The Planning Inspectorate
Yr Arolygiaeth Gynllunio

SCOPING OPINION:

Proposed Green Hill Solar Farm

Case Reference: EN010170

Title: Figure 3.1.1 Location Plan
Green Hill A & A2

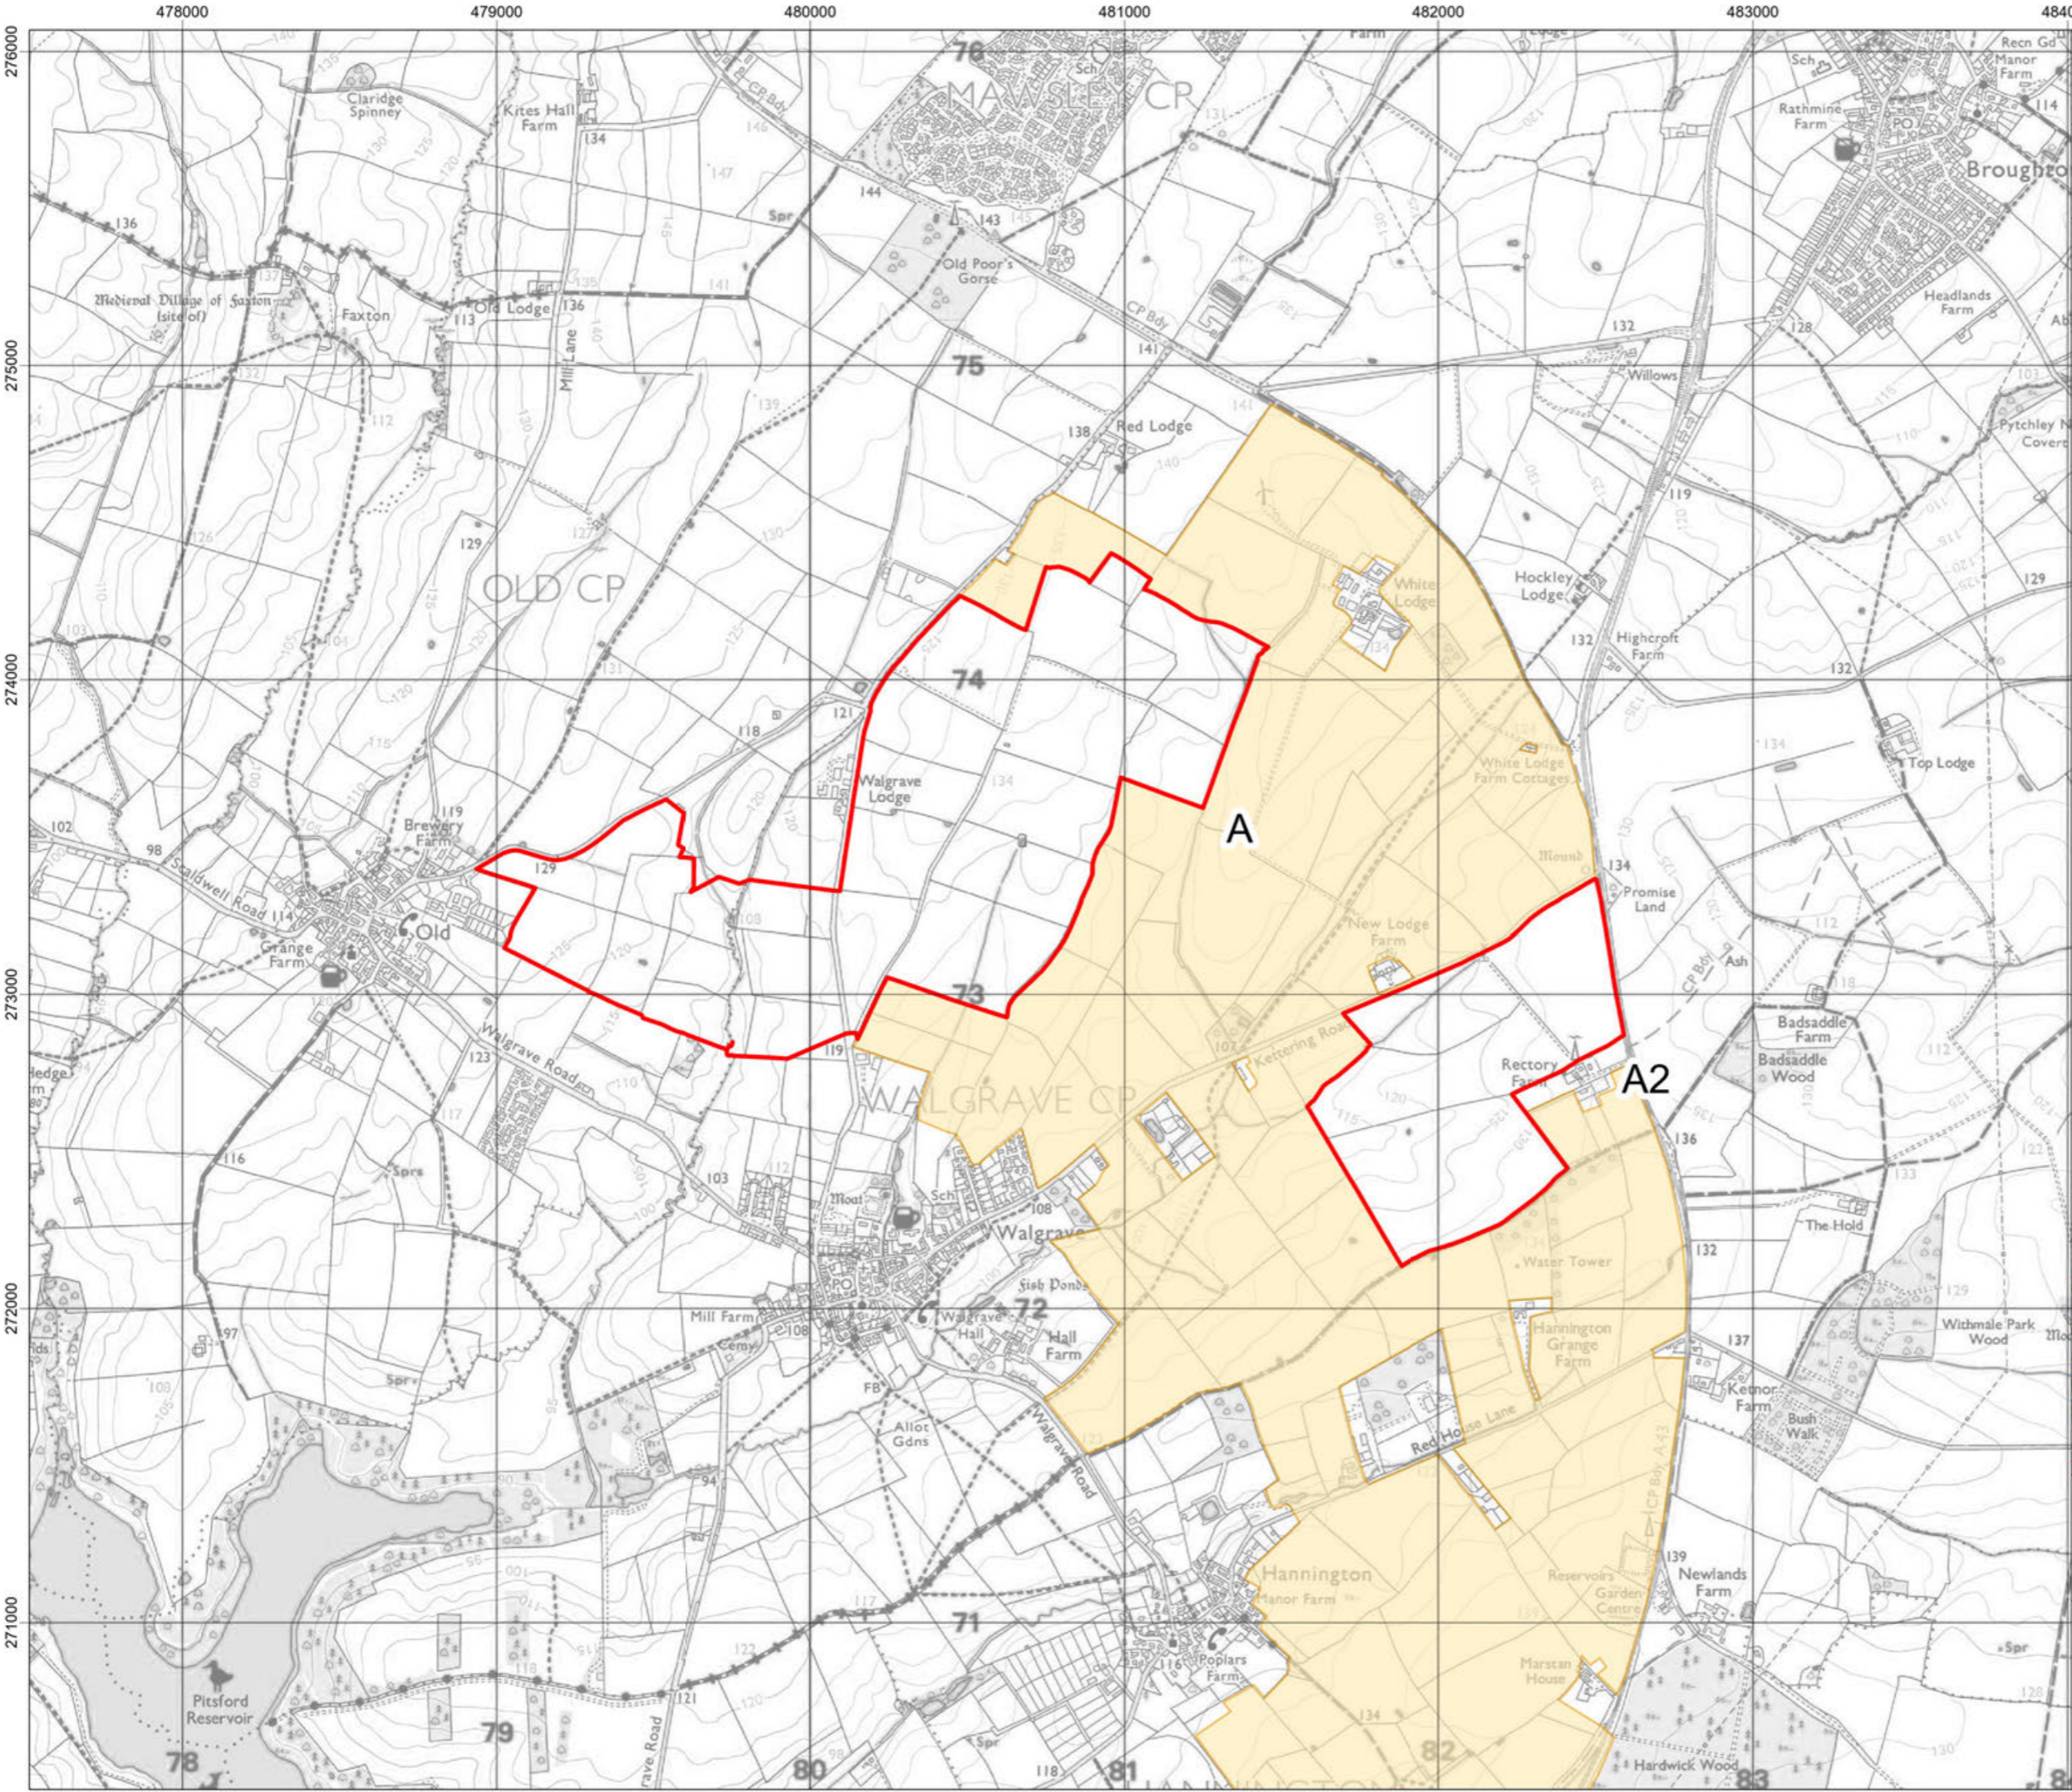
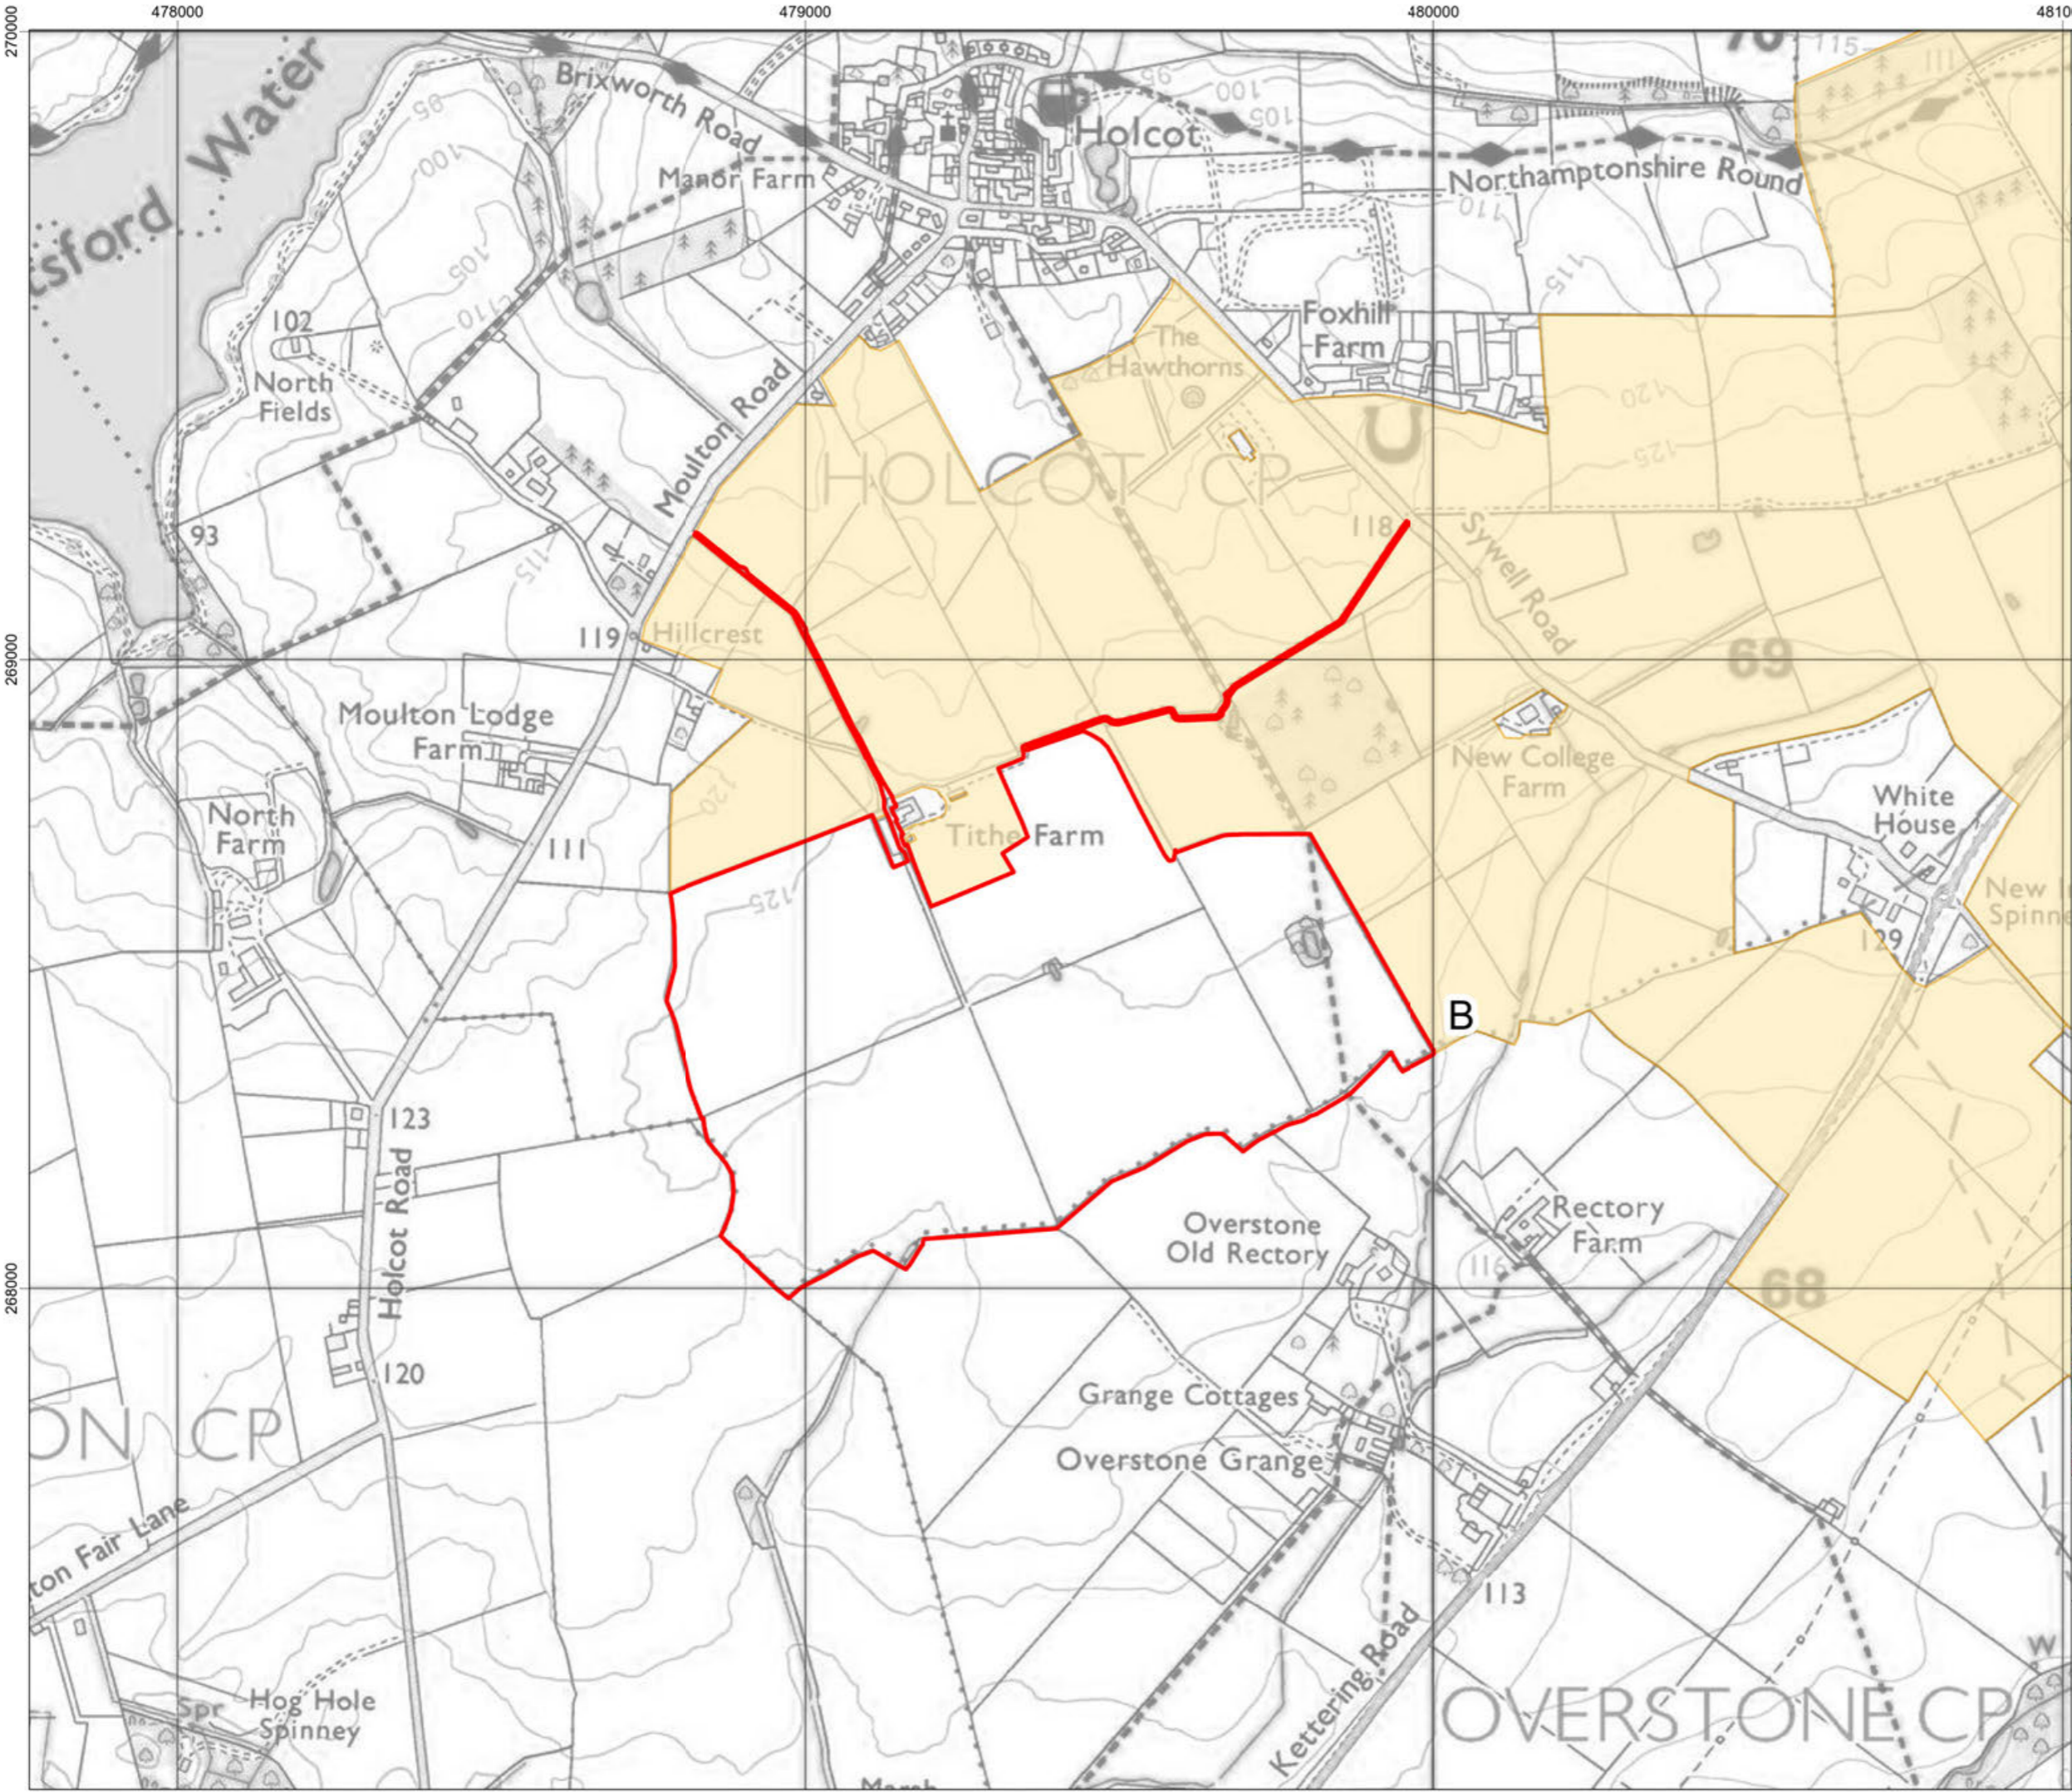
21.14		Figures – red line boundary	The Inspectorate notes that in figures provided the red line boundary denotes only the site areas that contain the solar panels and AD; and the Cable Route Search Area is hatched separately. The red line boundary depicted on the ES figures should encompass the entire application site, ie Sites A – G, the BESS site and the Cable Corridor.
